Our Ref: A/41/20/HH
Your Ref:

Town & Country Planning Act 1990 (as amended)
Town & Country Planning (Development Management Procedure) (England) Order 2015
Application for Planning Permission for Works or Extension to a Dwelling

Development Erection of Timber Cabin to Rear of Garden
Location 32 Chantryfield Road Angmering

PLAN

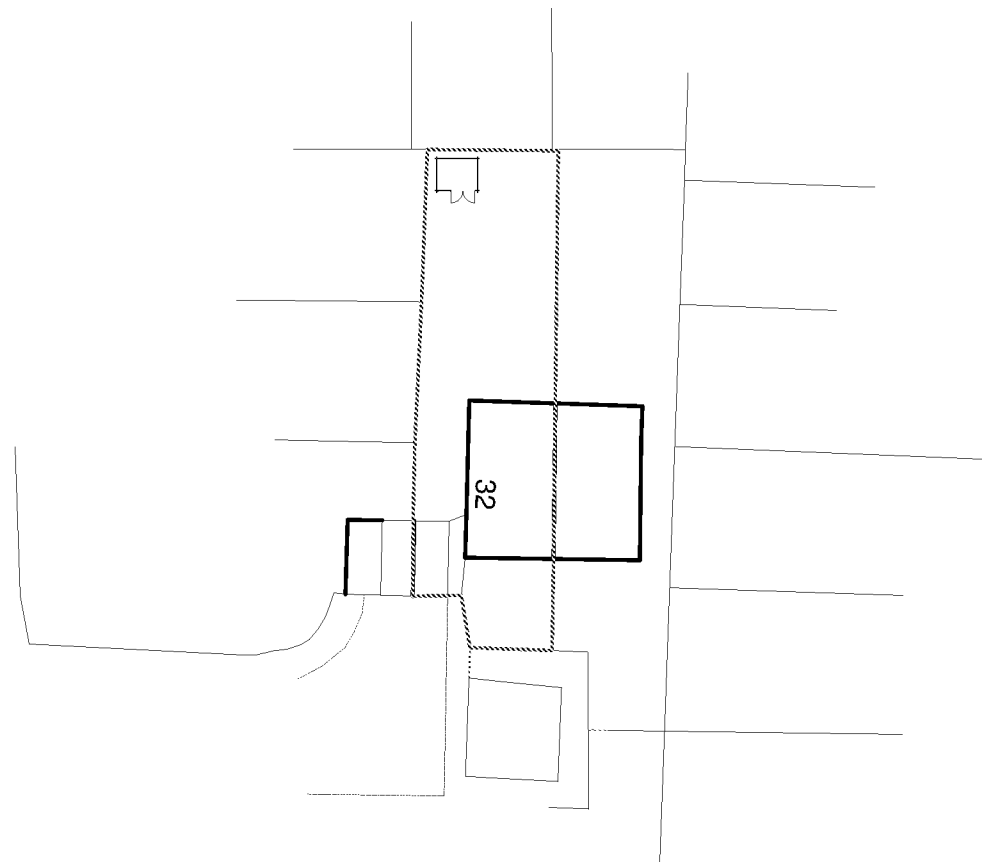
Room Label: You are required to include a room label on the proposed floor plan.

Dimensions: You are required to include dimensions from the proposed extension to all site boundaries.
